October 30, 2014

Re: 131 New Island Avenue, Peaks Island – 085-G-003 – IR-2 Island Residential Zone –  
Permit #2014-02458 – unpermitted deck

I have reviewed your application to permit the 9'10" by 16' deck and 3'9" by 4'8" shower area that was built at your property without a building permit. I am denying your permit because the structure does not meet the setback and lot coverage requirements.

X2 Overhead of Deck

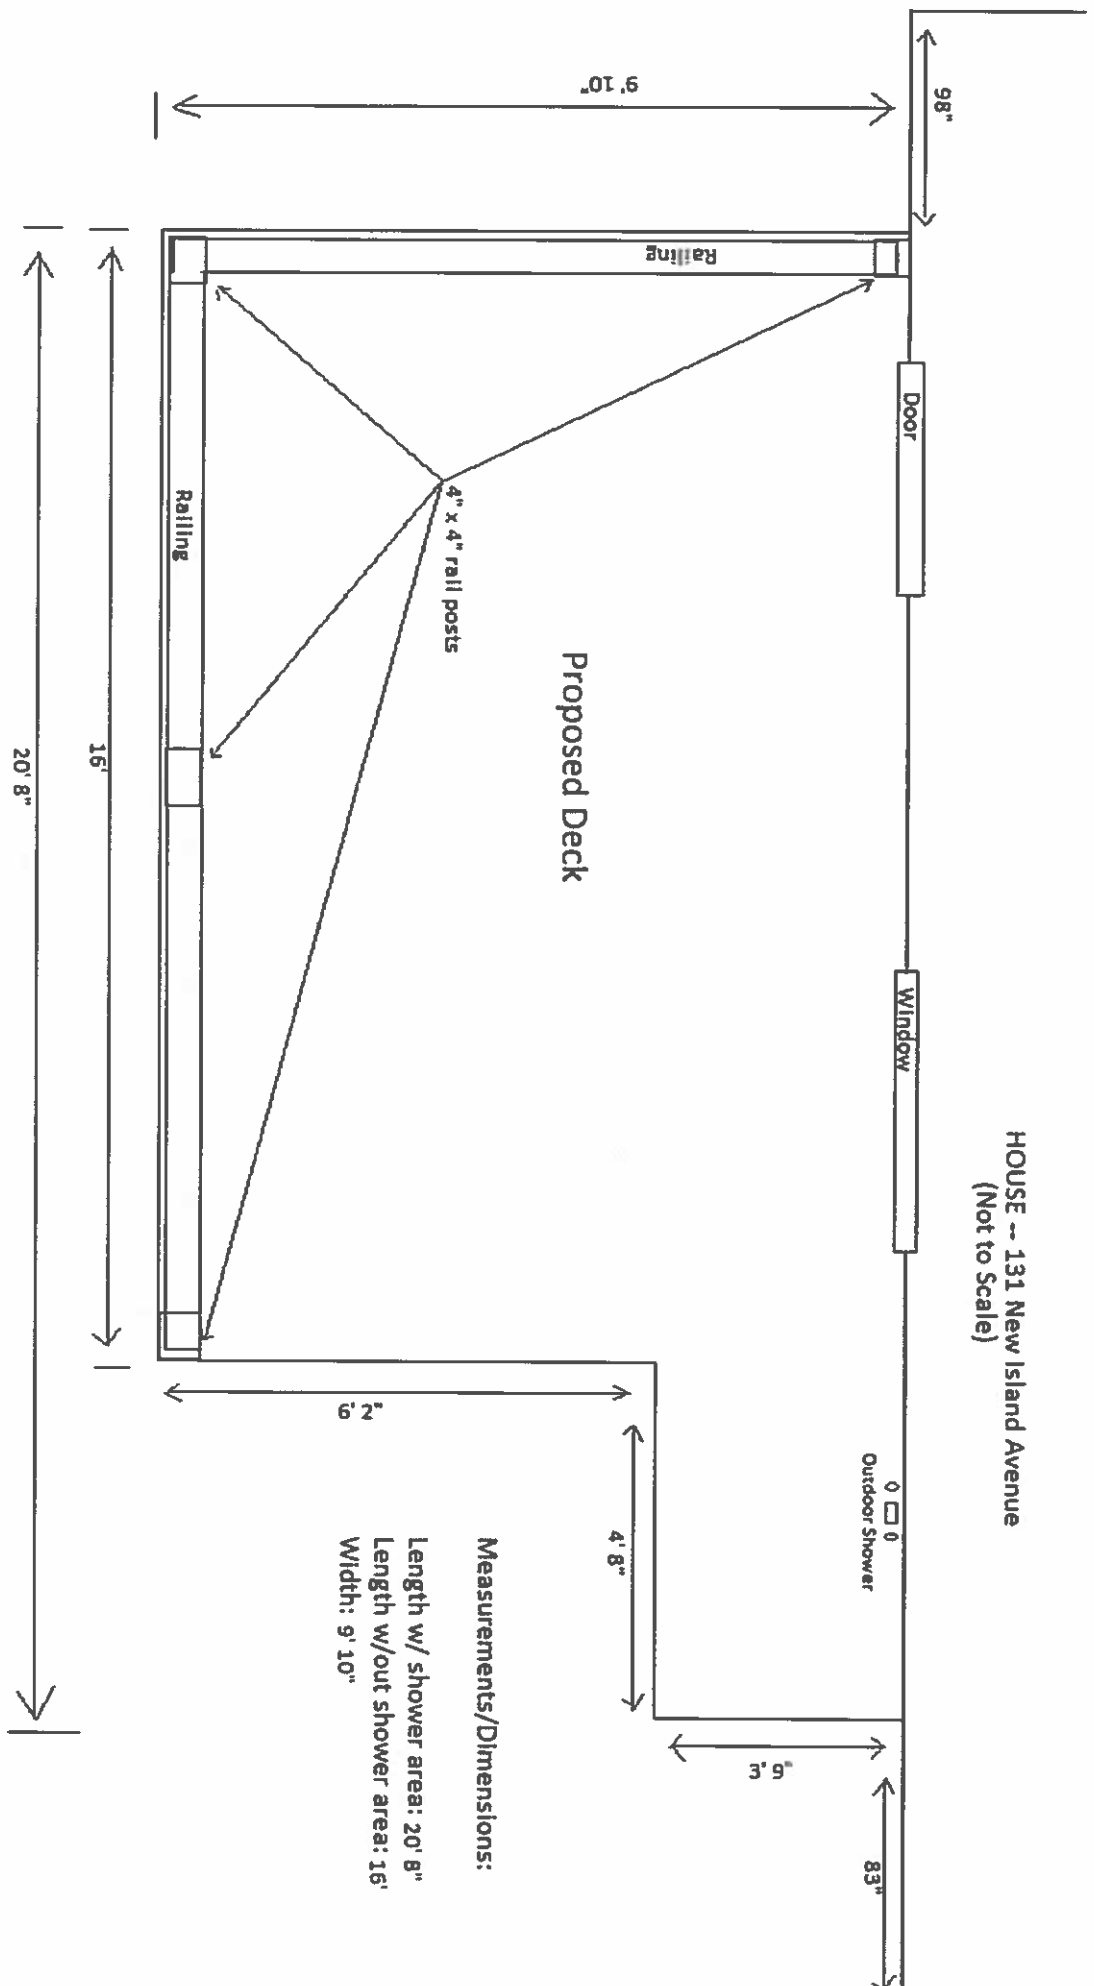
131 New Island Avenue, Peaks Island is located in the IR-2 Island Residential Zone. Section 14- 145.11(c) spells out the minimum required setbacks. The minimum required front setback is twenty-five feet, and the minimum required rear setback is twenty-five feet. The plot plan that was provided with the permit appears to have given the front and rear setbacks from the edge of the streets and not from the property lines. Where the proposed deck sits on the lot, the lot is only fifty feet deep. The deck is 20'8" long. If you subtract that from 50', the difference is 29'4". The 25' front and rear setbacks cannot be met.

Section 14-145.11(d) states that the maximum lot coverage is twenty percent of the lot. The lot is 5,550 square feet. The footprint of the existing structure is 1,116 square feet. The deck and shower area is adding 174.8 square feet. The new footprint would be 1290.8 square feet which covers 23.3% of the lot. This exceeds the allowable lot coverage of twenty percent.

You need to bring your property into compliance. Since the deck and shower area does not meet the required setbacks or allowable lot coverage, it cannot be permitted and it needs to be removed. You have thirty days to remove the deck.
